**Comment Letter for Proposed Redevelopment of 6950 SE Maker Street, Permit 2207-019**

My name is Dan Grove and I live at 3515 72nd Ave SE. I'm writing as a concerned neighbor who shares a property boundary with the proposed development (submission documents [here](#)) at 6950 Maker Street ("The Project", owned by The Strand Trust). As a long-time member of the Mercer Island community, I was surprised and dismayed to see a proposal for a house much larger than permitted by code, a house built to a height of 34+' on top of an artificially elevated lot, a house that would be built on a lot with a history of rockery problems and a house whose development was enabled by significantly damaging an exceptional tree. That this proposal was submitted without any discussion with neighbors of the property makes it even more troubling.

BUILDING ELEVATIONS

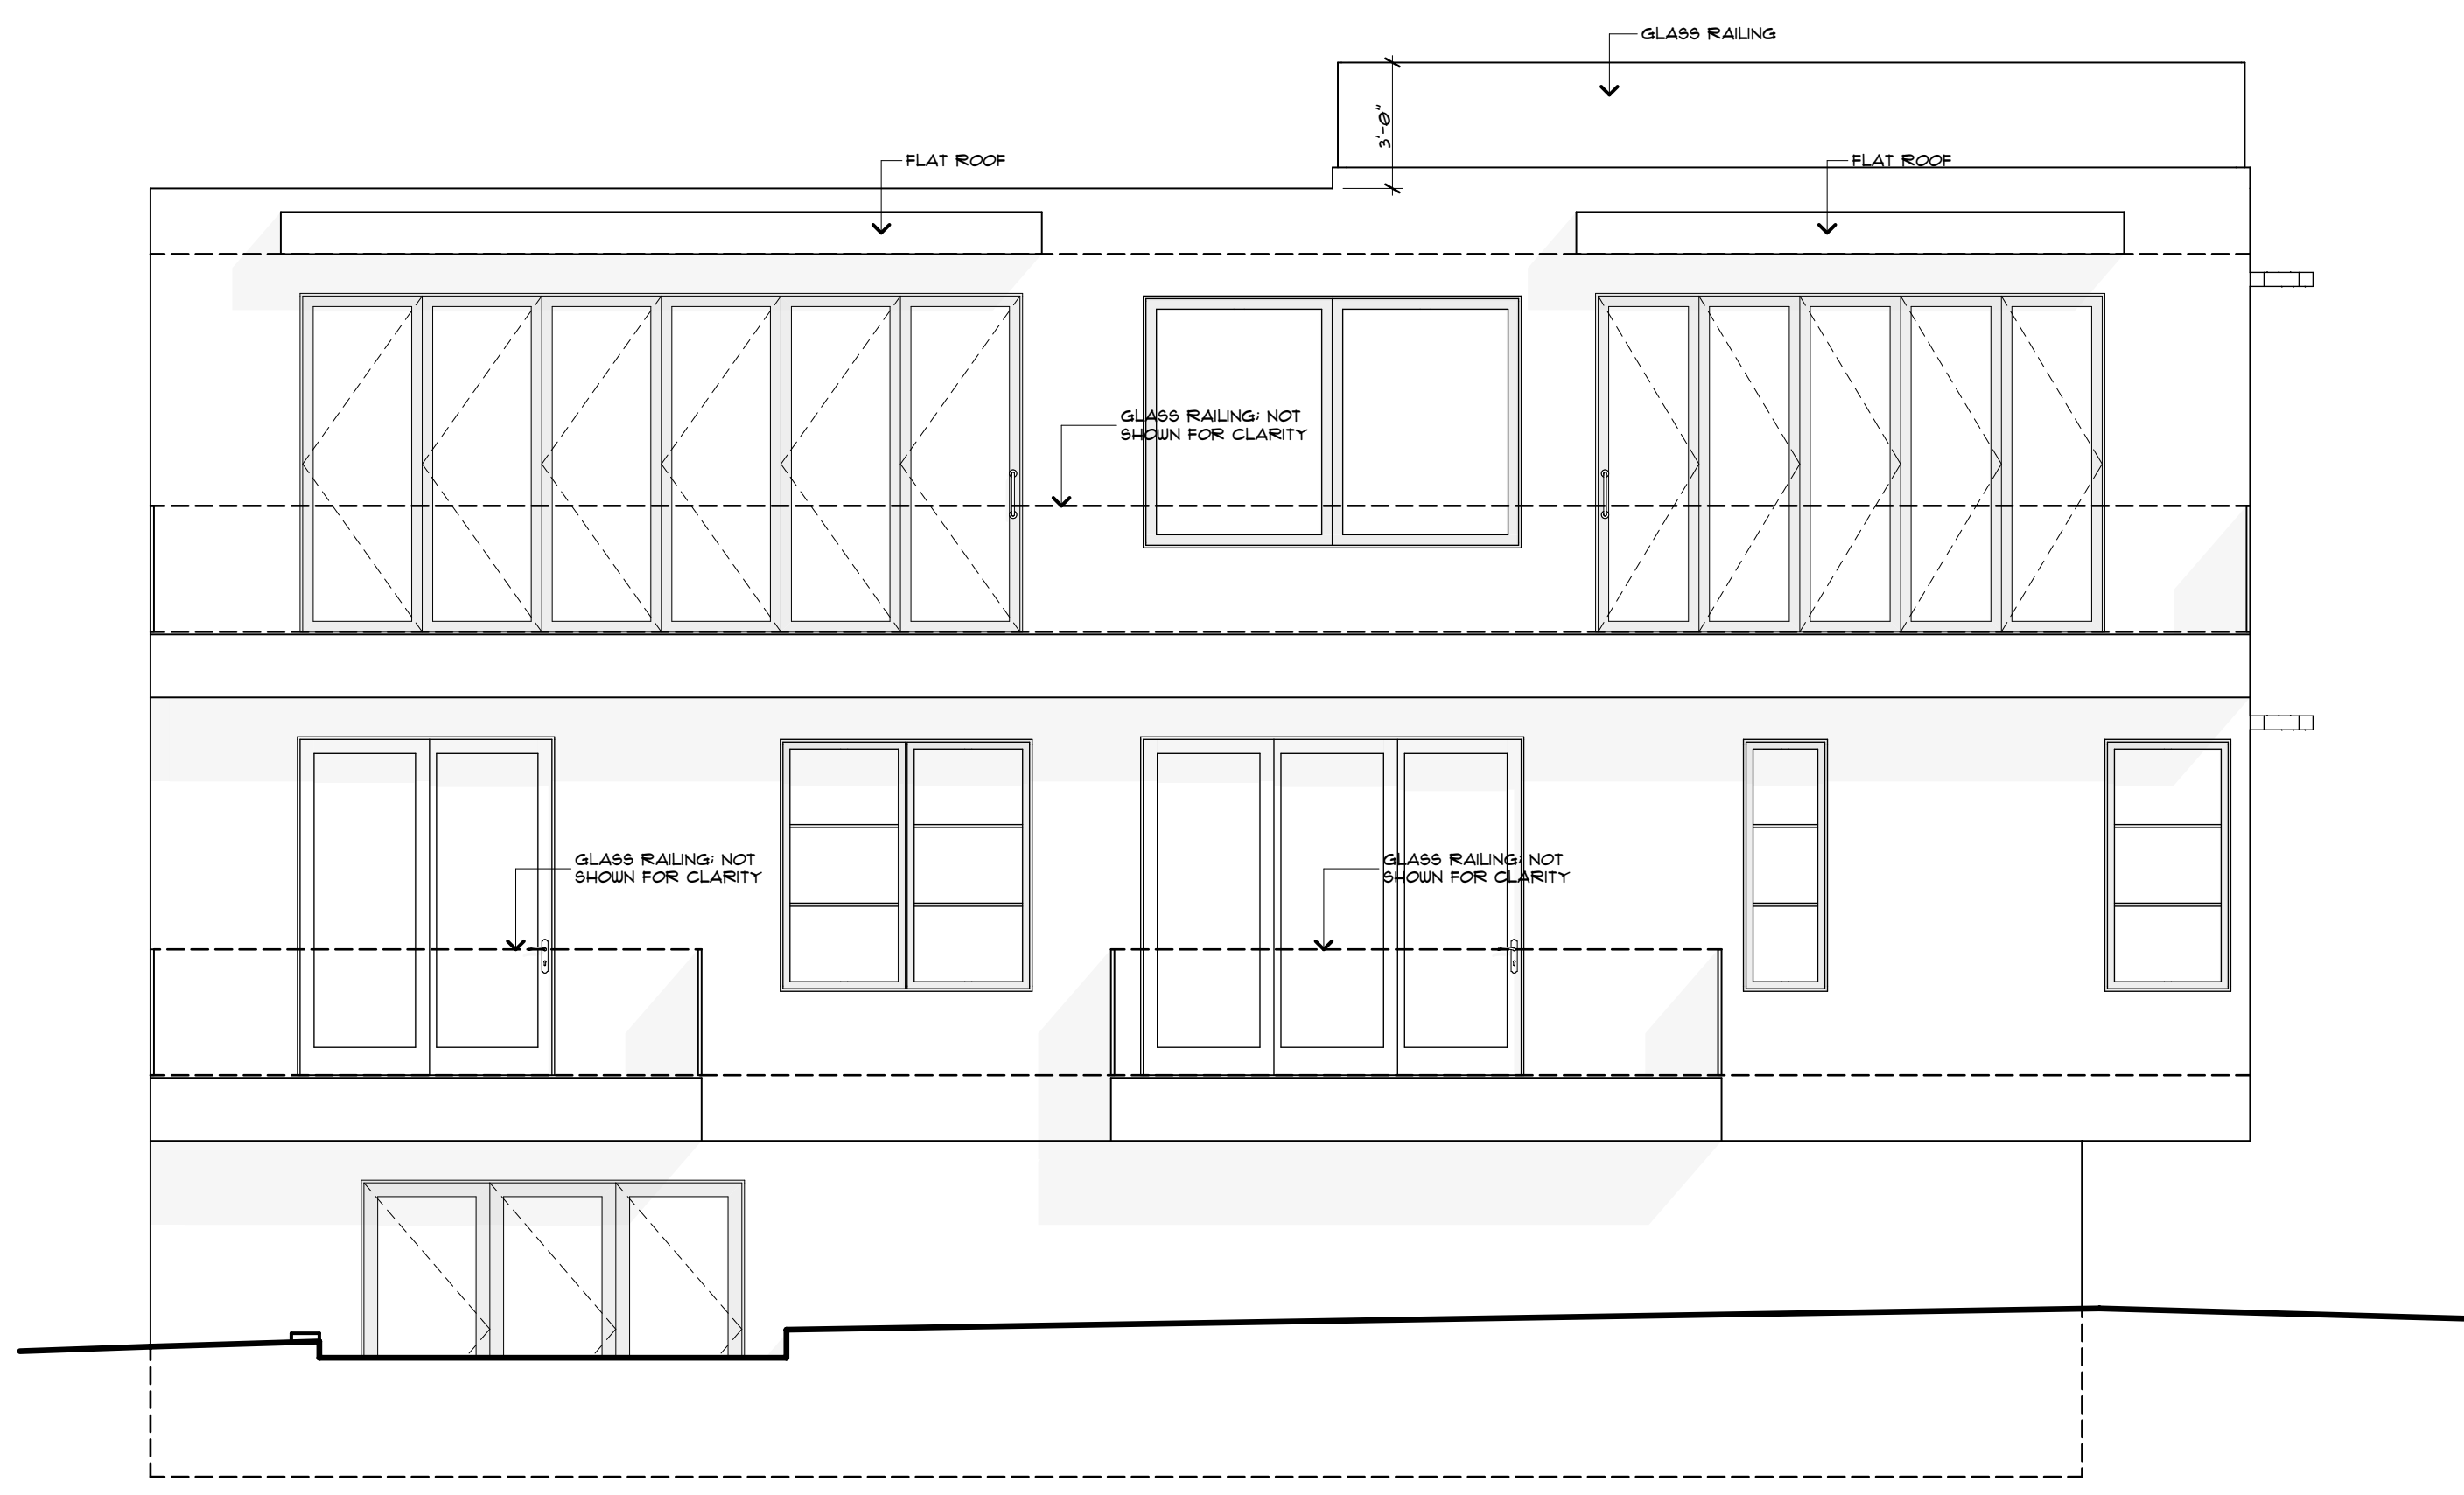
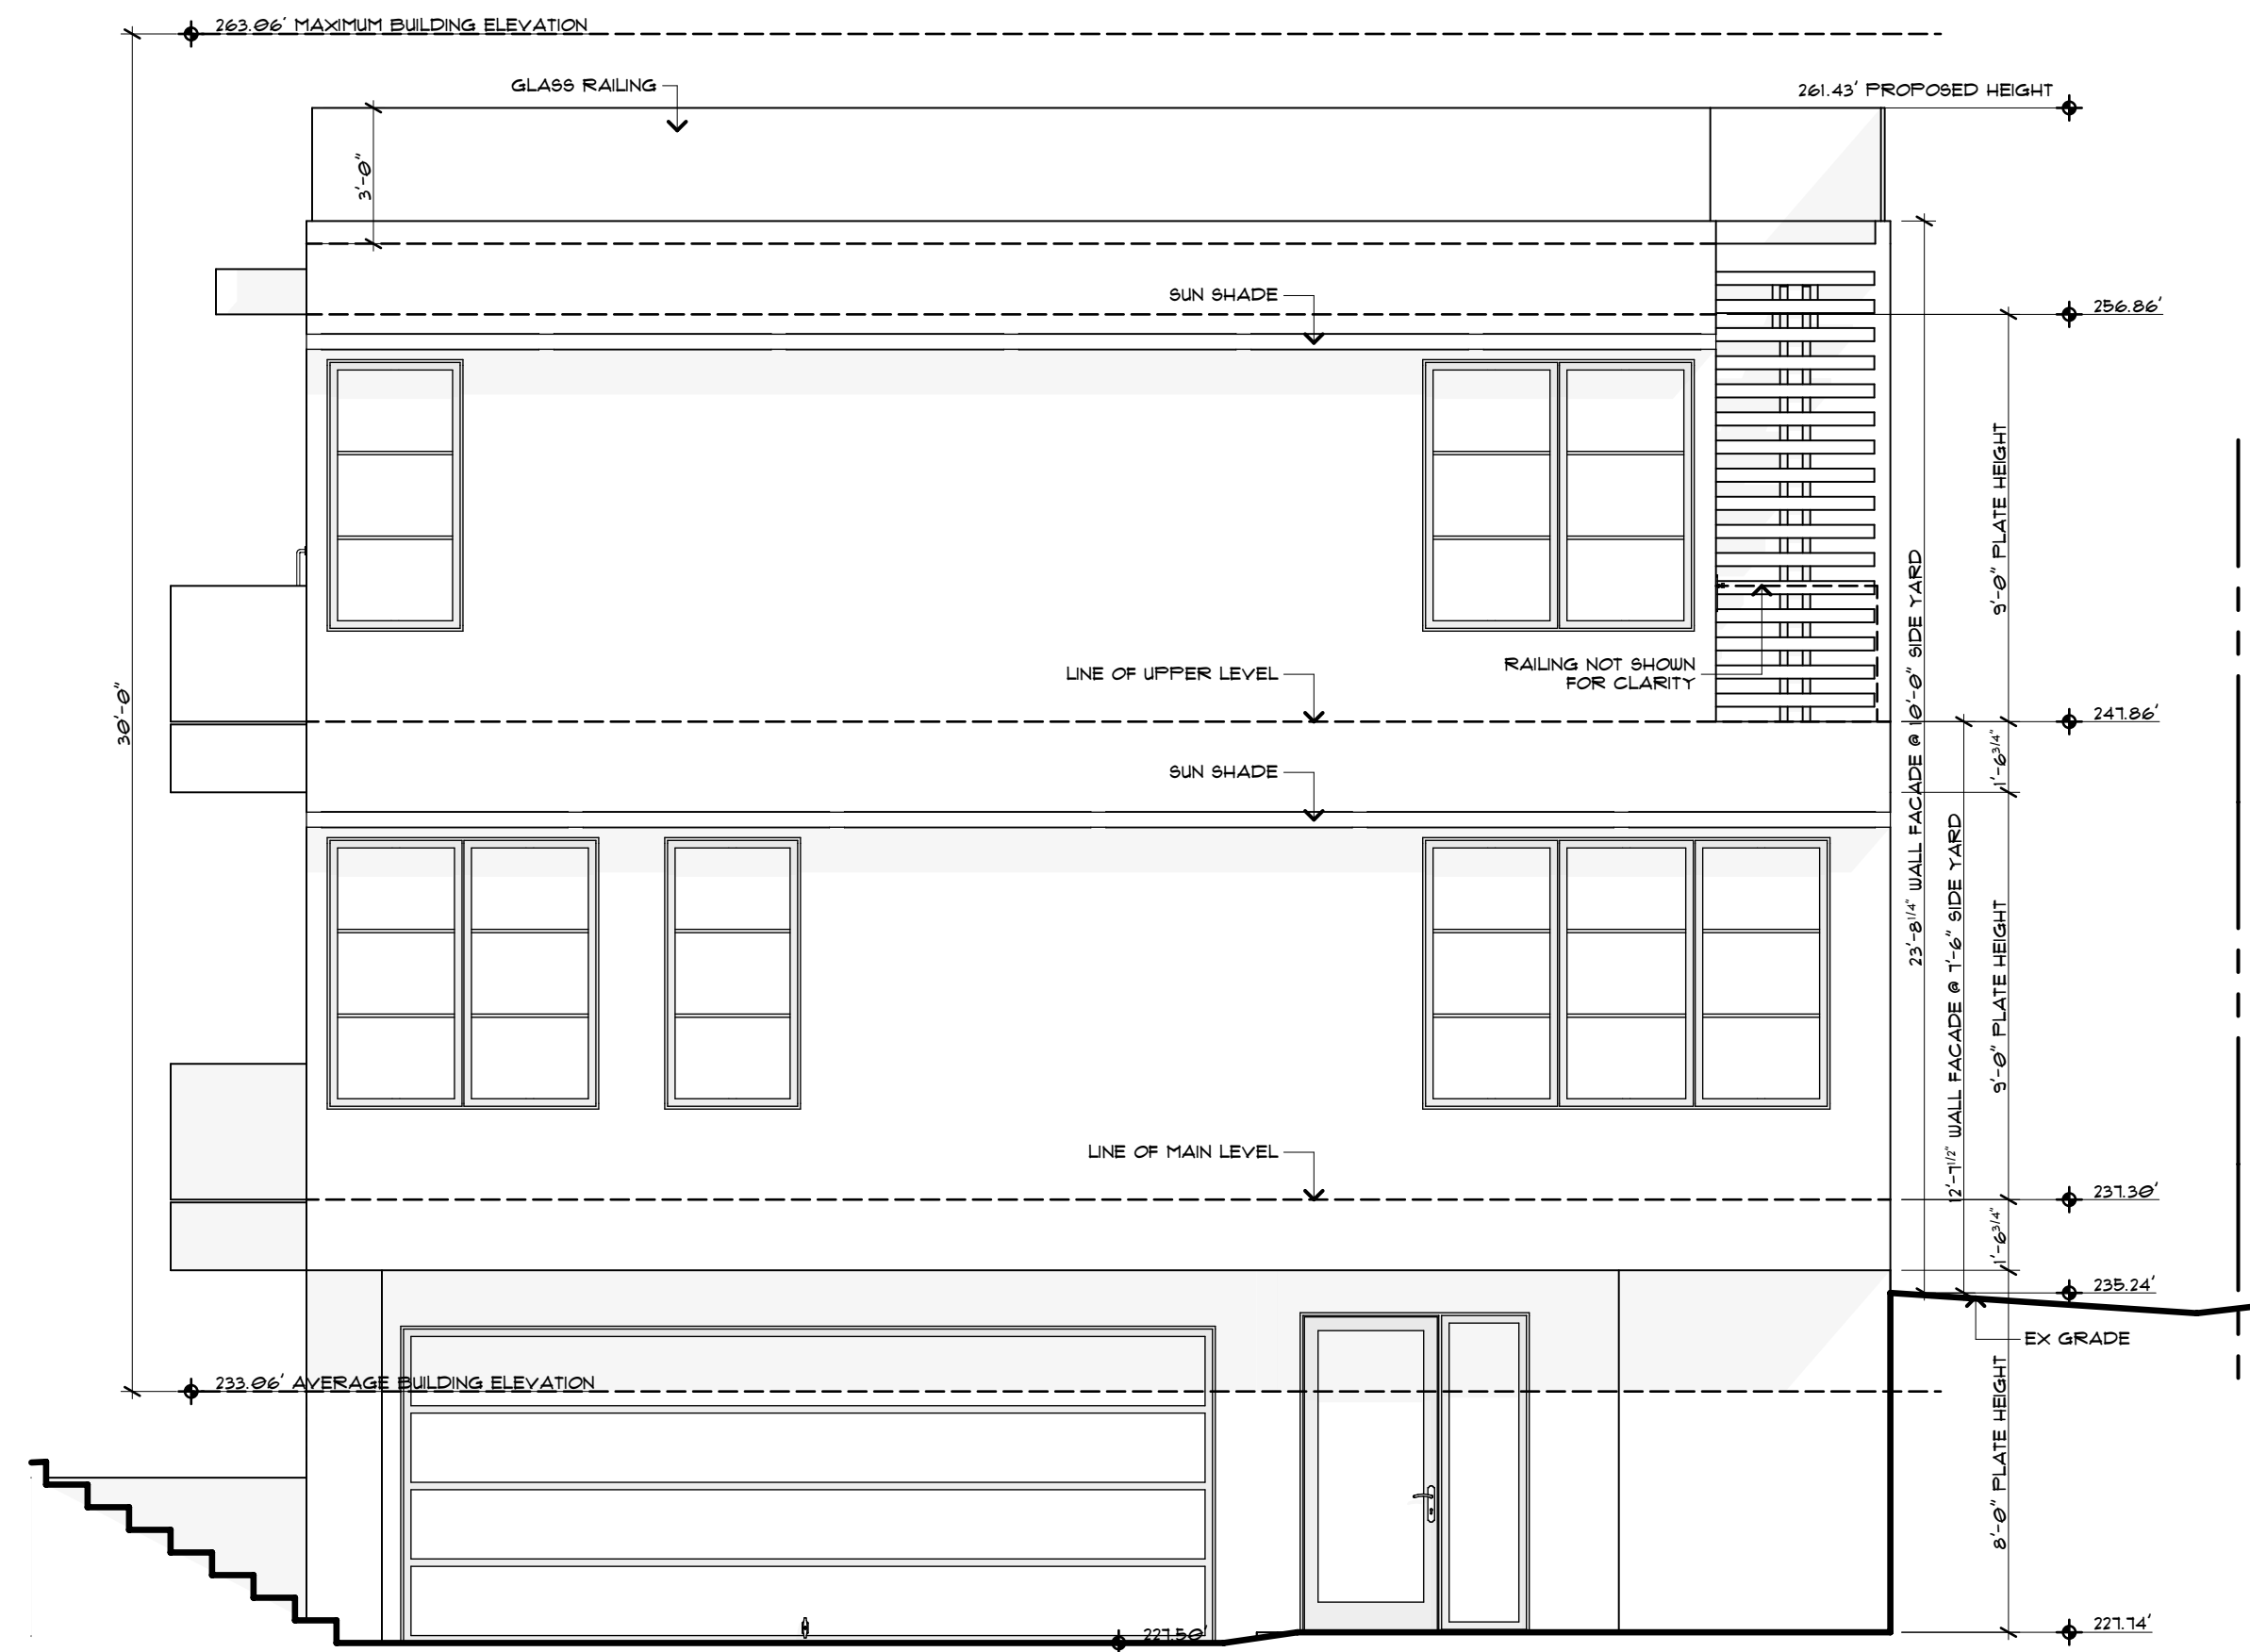
Consequently, the applicant incorrectly computes the Average Building Elevation<sup>2</sup> ("ABE") as 233.06.' My data offers multiple forms of evidence that the correct ABE is approximately 226.7'.

- Because Average Building Elevation is computed incorrectly, The Project exceeds the maximum building height by more than 4'.
- Because Existing Grade is computed incorrectly, The Project exceeds the Maximum Building Height on a Downhill Slope by more than 8'.
- Because The Project's Gross Floor Area ("GFA") incorrectly excludes the entire basement (indeed, the entire lower level), The Project exceeds its maximum GFA by more than 1200 square feet (beyond the 3500 square feet allowed).
